# CITY OF ALBUQUERQUE

June 15, 2006

**Re: RV Storage on Gibson, 1400 Gibson Blvd SE**  
**Conceptual Grading and Drainage Plan**  
**Engineer's Stamp dated 5-02-06 (L15-D49)**

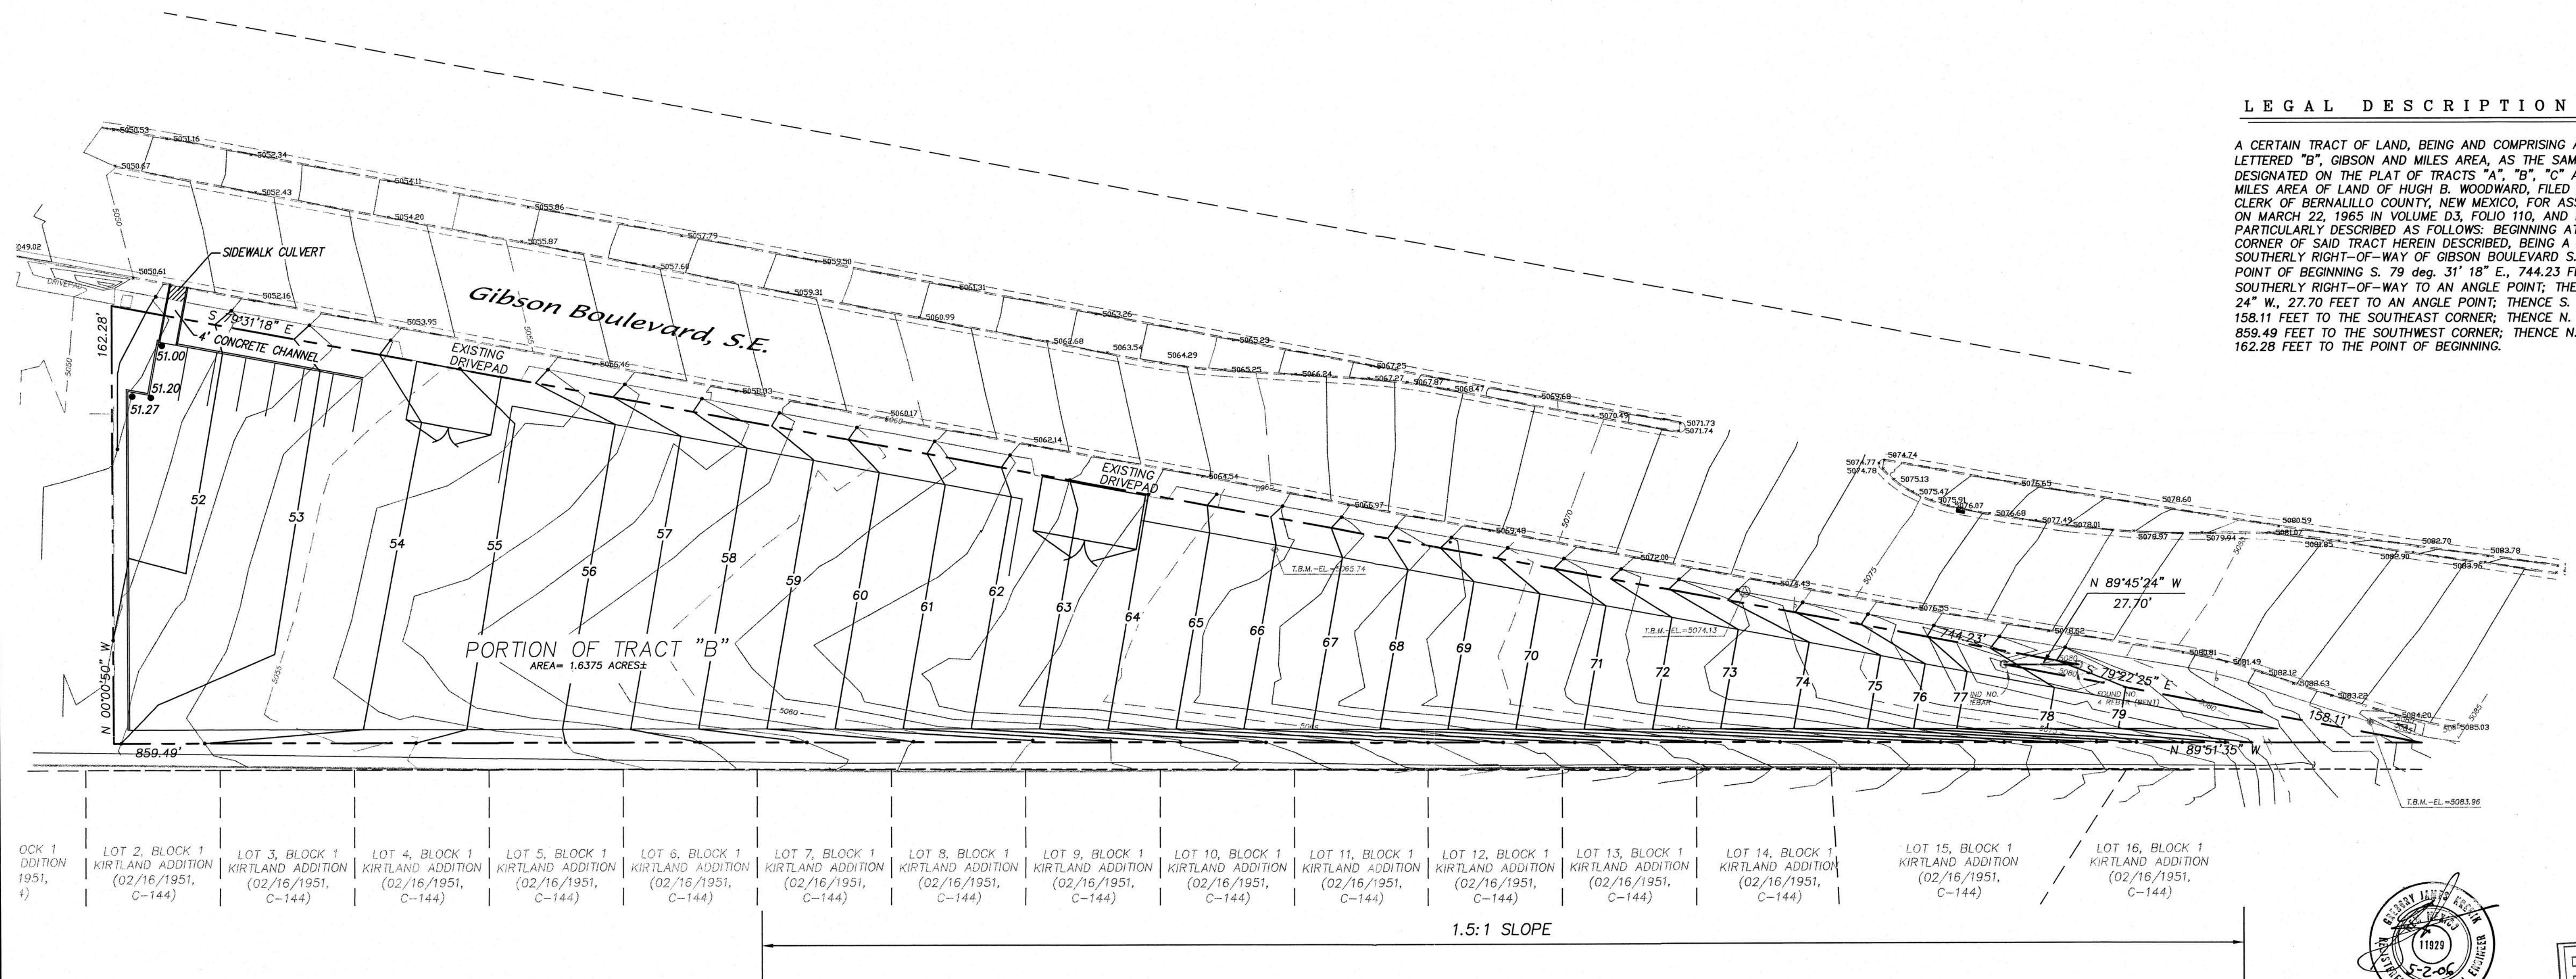
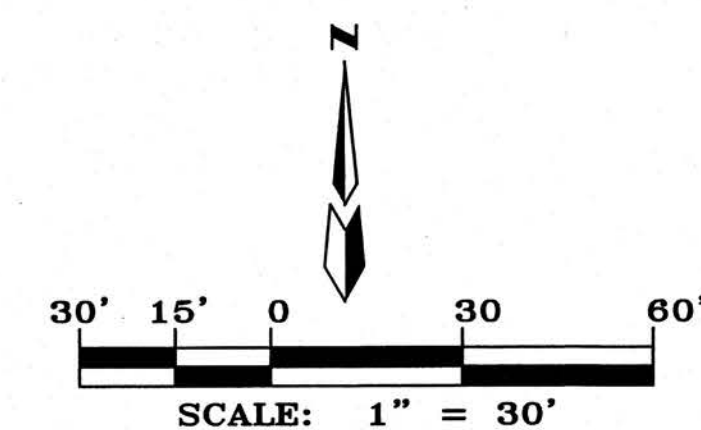
Before a building permit can be issued for this site, drainage calculations will be needed quantifying the amount of discharge leaving the site address off site flows and provide channel calculations.
